# ADDITIONAL INFORMATION REPORT

MP 11\_0048

61 MOBBS LANE, EPPING – STAGE 2

MARCH 2012

2 SOUTH-EAST ELEVATION
1 : 100

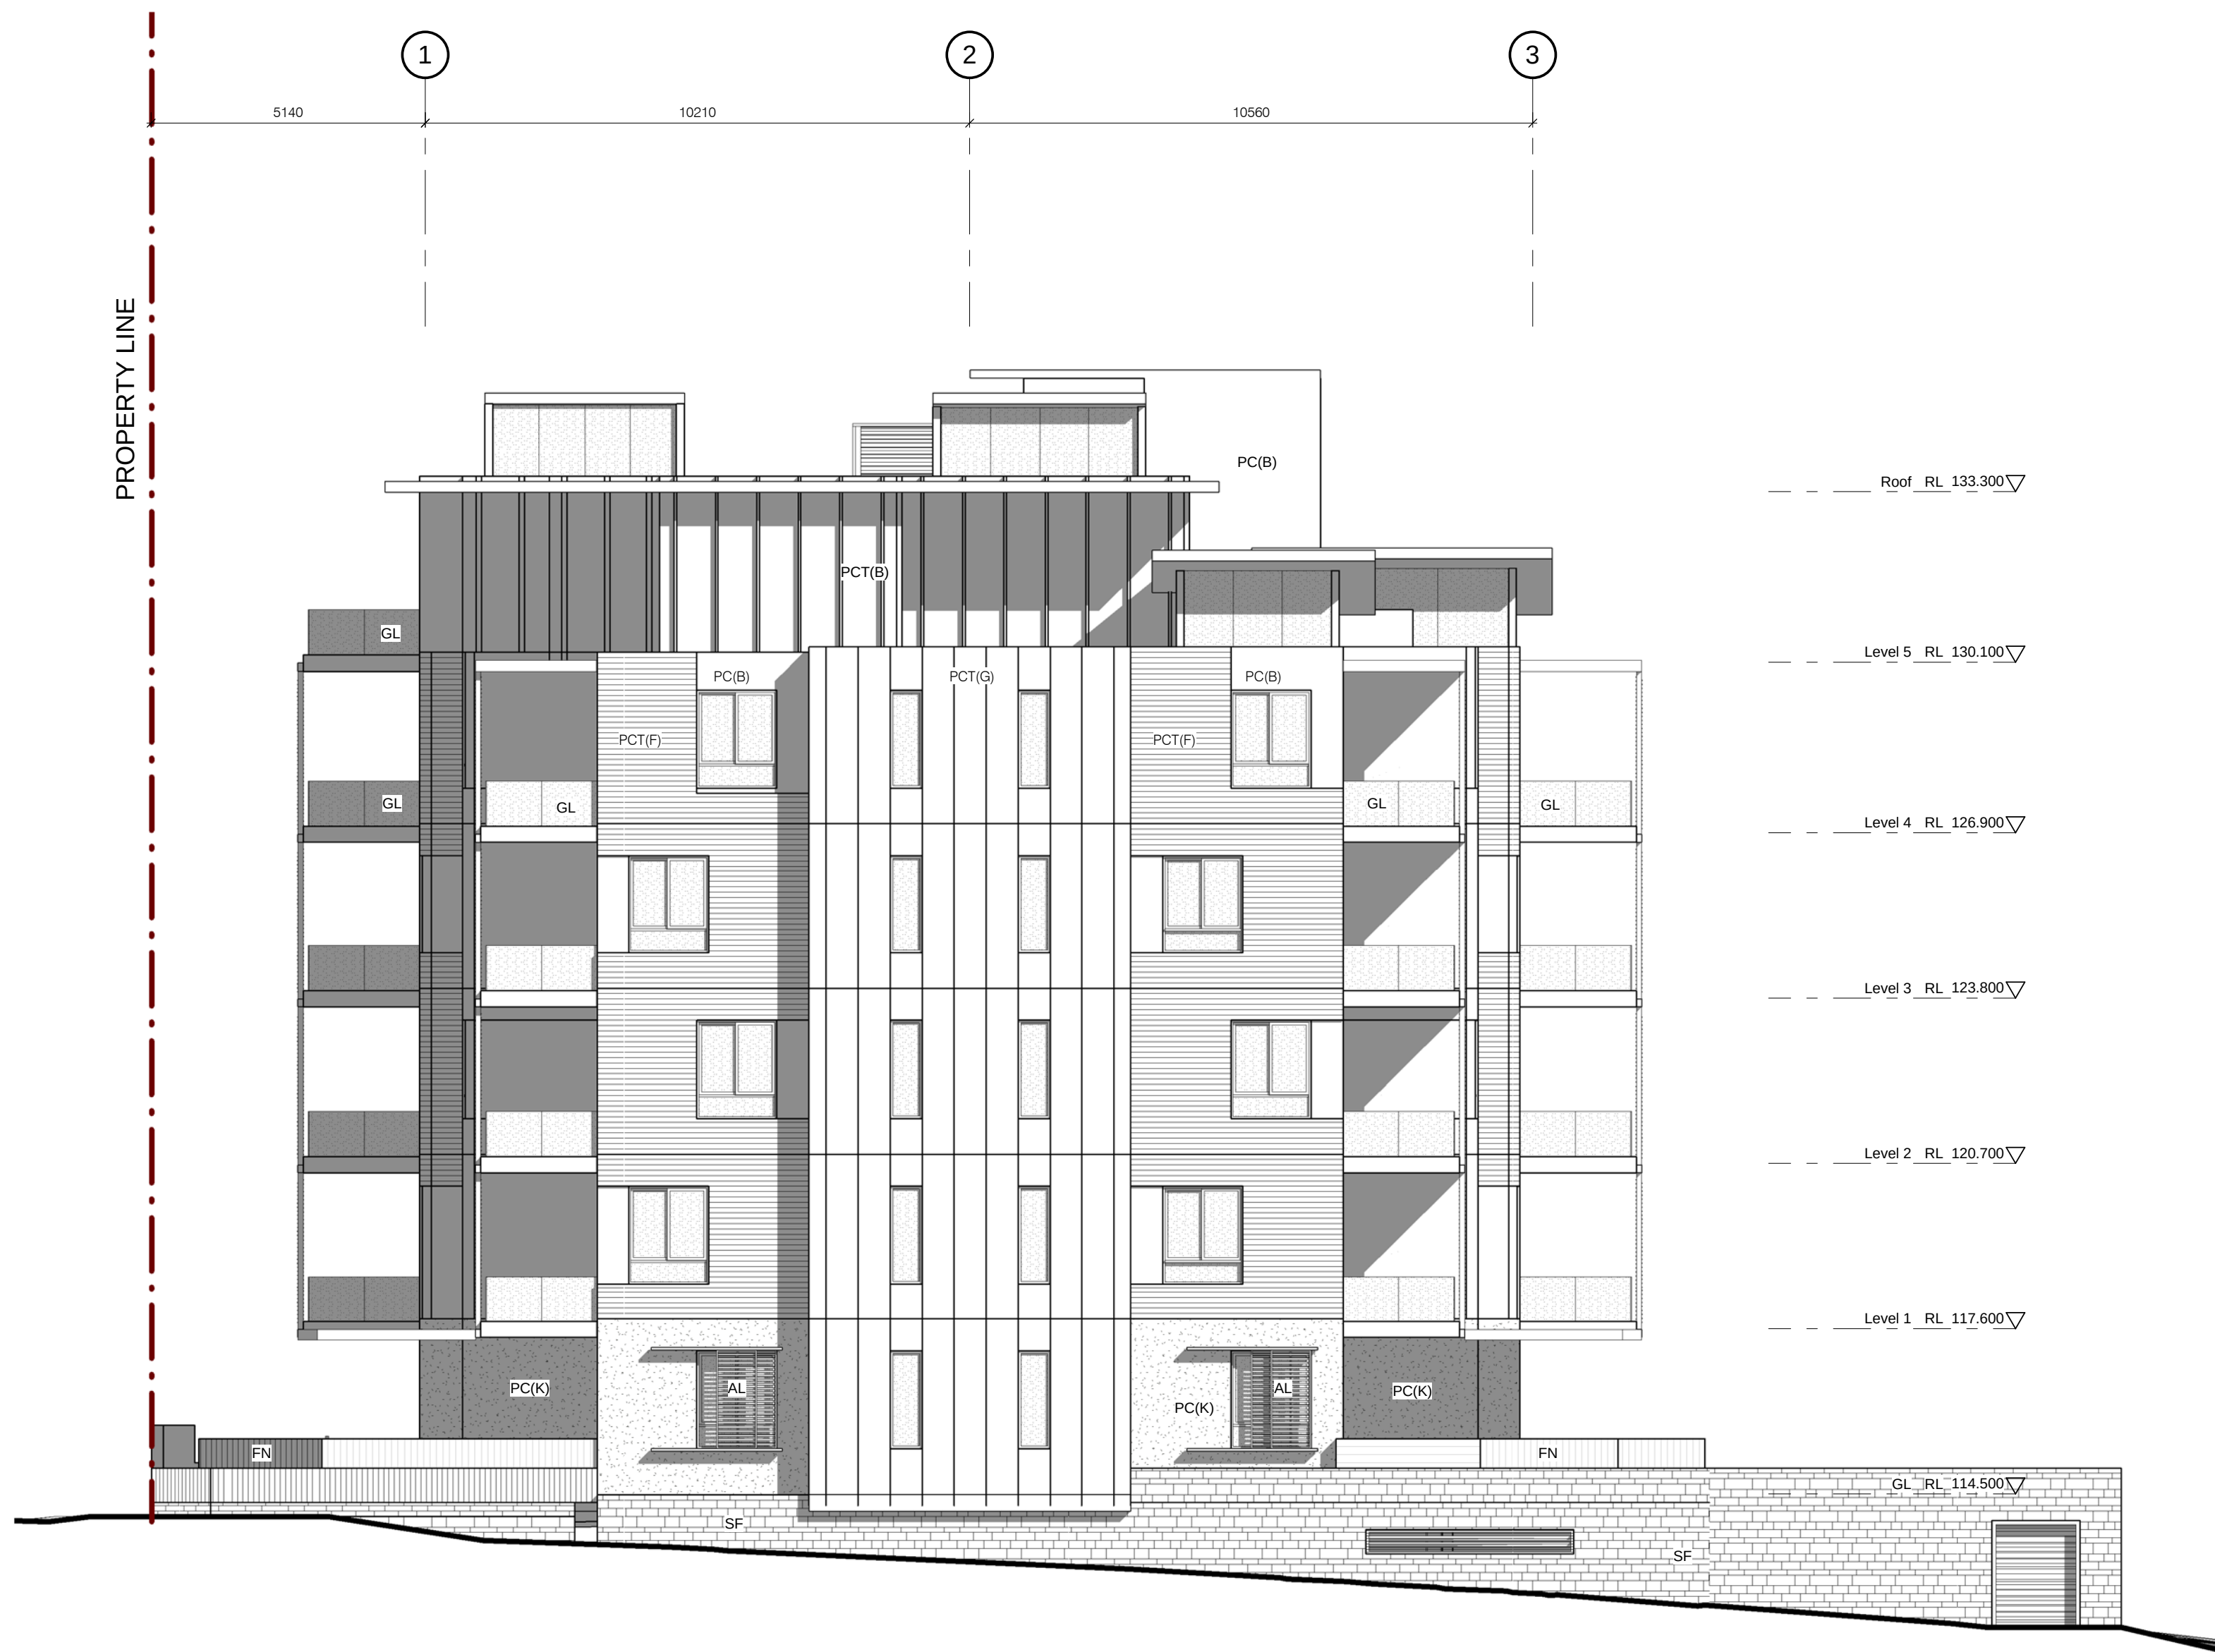
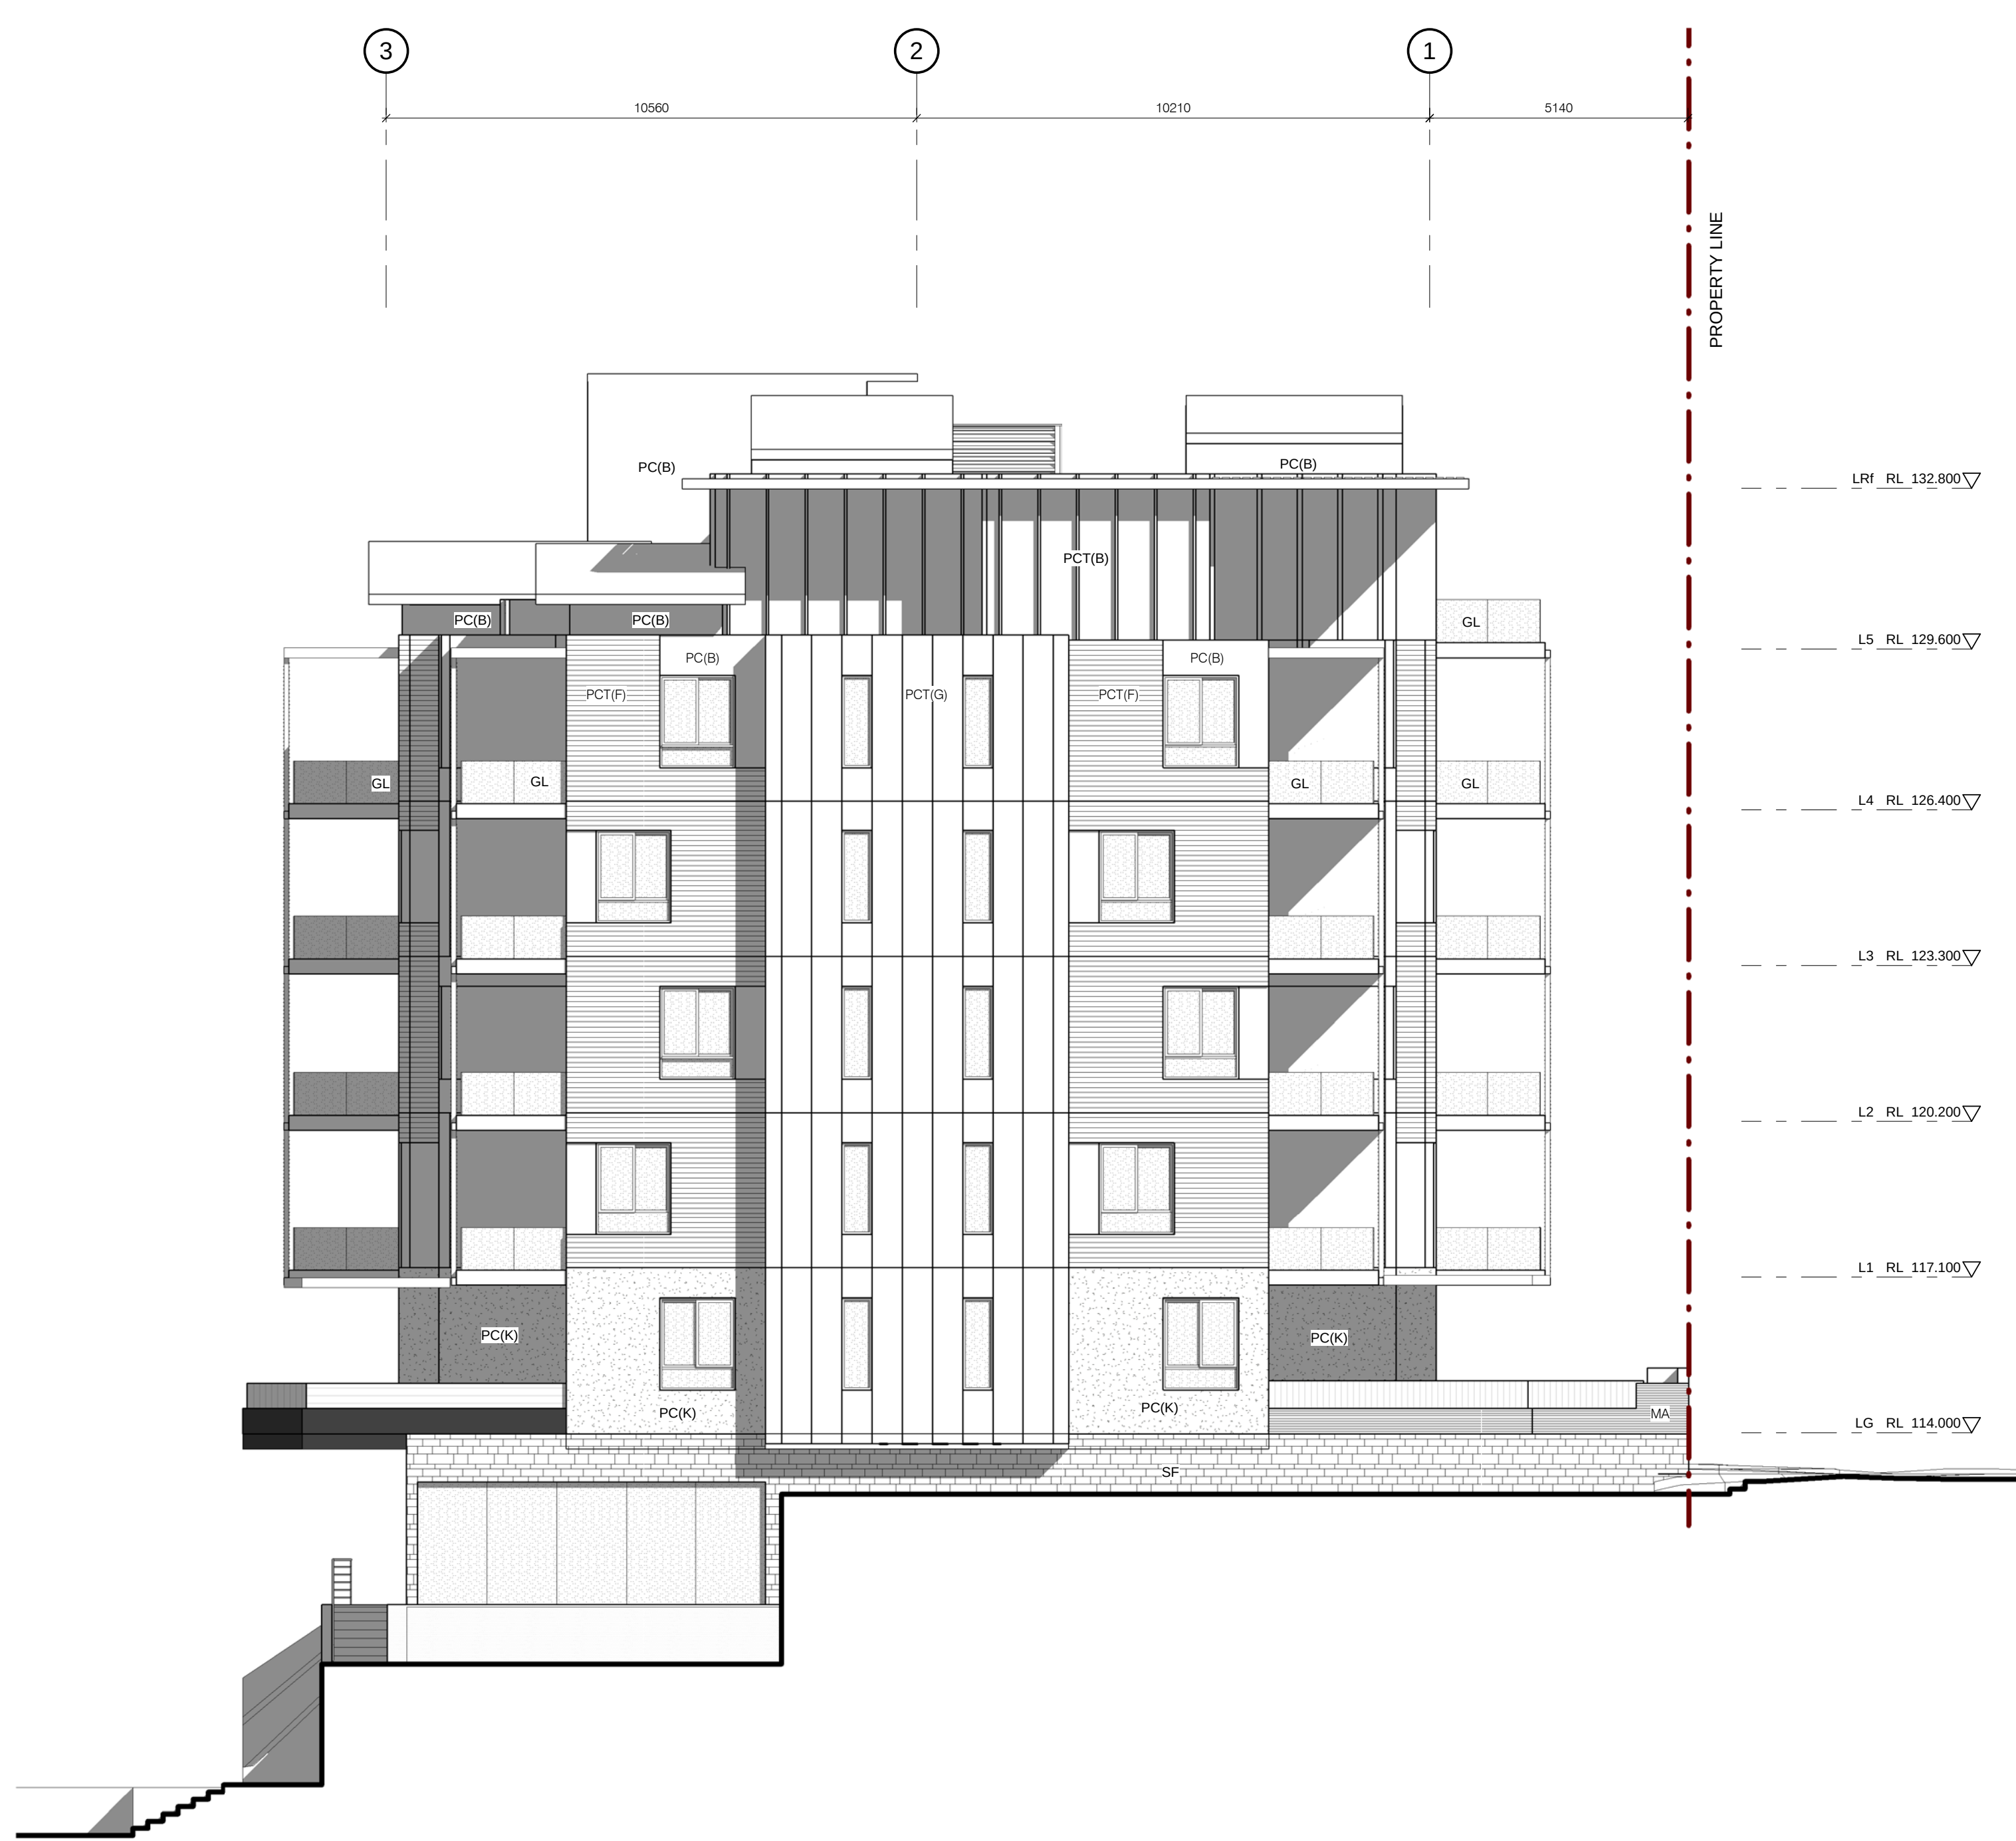
**Issue:** The south east elevation does not include ground level detail between Building 6 and 2.

**Response:** Architectural plans have been amended to show detail between Buildings 2 and 6. Refer to ***Annexure 3***.
